Engineers Comments Regarding Surface Water Drainage

Application Reference:	AL/13/25/DOC	Reviewer Reference:	ADC/EXT2/D2134/70
Planning Officer:	Hannah Kersley	Date of Review:	29.04.2025
Site Name:	Karenza Hook Lane Aldingbourne PO20 3TB		
Application Description:	Approval of details reserved by condition imposed under reference AL/154/23/PL (APP/C3810/W/23/3335883) relating to condition number 3 - Construction Management Plan, condition number 5 - surface water drainage scheme, condition number 8 - external materials and finishes and condition number 9 - energy.		
Assessment Number:	1 of 2

Title DRAINAGE LAYOUT
2 OF 2

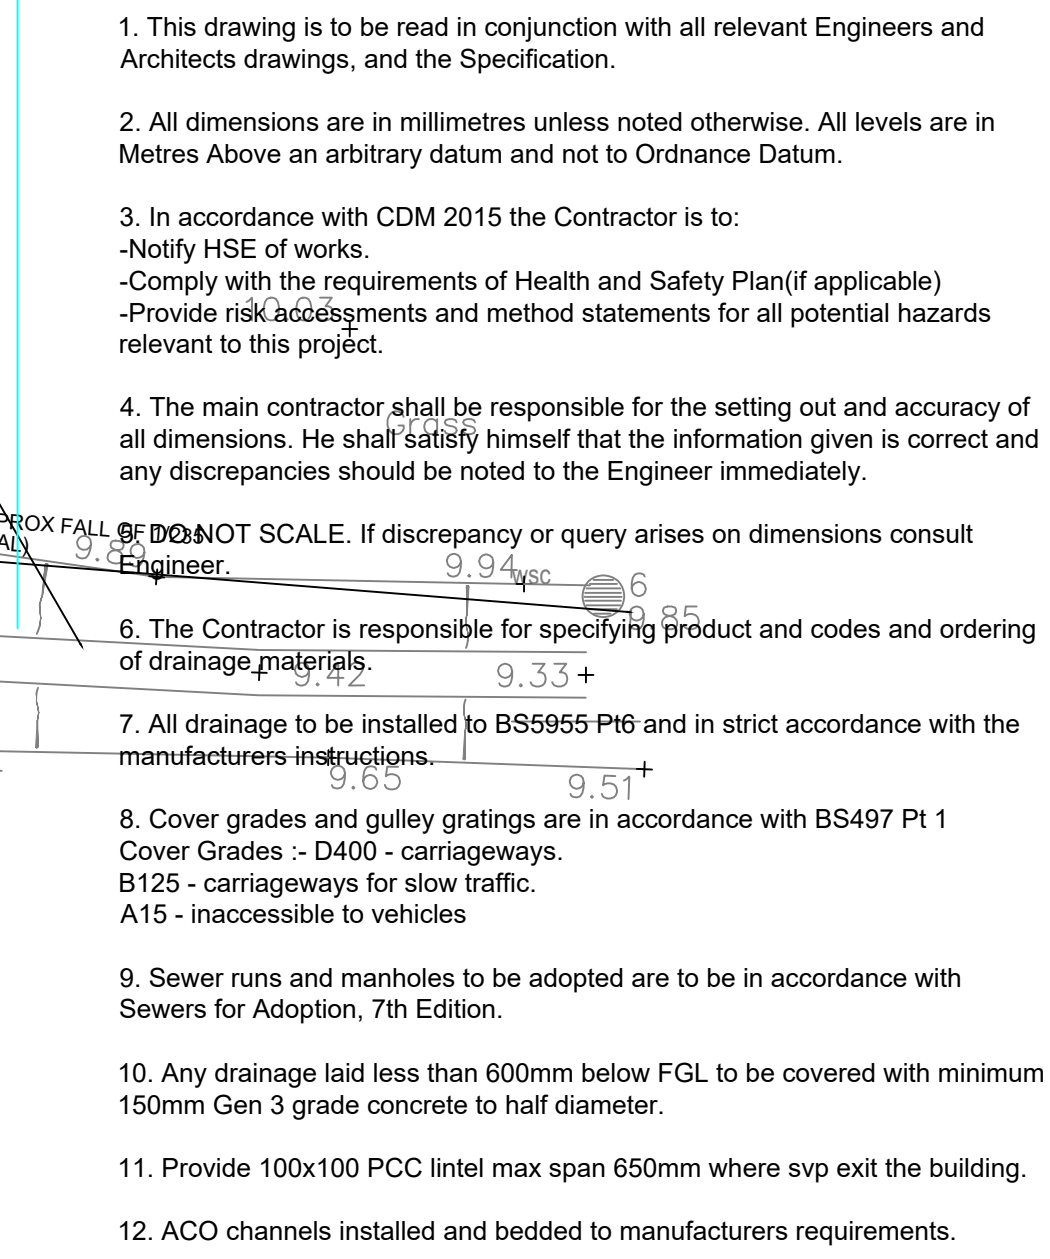
9.	The drainage strategy report, 4.16 makes reference to urban creep of 10% being included, however this calculation is not demonstrated clearly on drawing 435050-221P2.	Please see drawing no. 435050-220P

14.	The hydraulic calculations specify node SW-13 as a vortex flow control with an invert of 9.49m, however drawing 435050-221P2 shows this to be higher @ 9.494m. As cited above, for certainty the as-built levels must be used as they may not correlate with the phase 1 design.	Amended in the model

17.	A supporting node drawing overlay with the site layout and drainage arrangement is required in order review the 1D modelling.				
18.	The cover level and invert levels for numerous nodes do not appear to correlate wholly with drawing 435050-221P2.	updated

19.	Please explain wat is the relevance of a 1:500 return period has been demonstrated, also with CC.	This has been removed			
20.	Drawing 435050-221P2 is very difficult to review where phase 1 is greyed out and the key does not clarify all items i.e. its is assumed the pink text represents the phase 1 formation levels?	The revised drawing is clearer and also the construction issue of phase 1 has now been provided

21.	Drawing 435050-221P2 requires formation levels at all corners and at outlets/inlets of all permeable pavements.	This has been added			
22.	Rainwater pipes run through silt traps (catchpits) and into the permavoid. Please provide a construction detail of how this is interfaced.	Detail provided on Drawing 435050-222P

23.	Please provide construction details for all features identified on drawing 435050-221P2.	Detail provided on Drawing 435050-222P			
24.	Measures to protect the permeable pavement (asphalt construction) during the construction period must be annotated on the drawings to ensure that it does not become silt up prior to completion of the project.	See details on drawing 435050-222P

30.	Drawing 435050-221P2 is very light on spot levels, no contours it is not possible to deduce where exceedance run-off will travel.	Exceedence flow layout provided in Appendix E
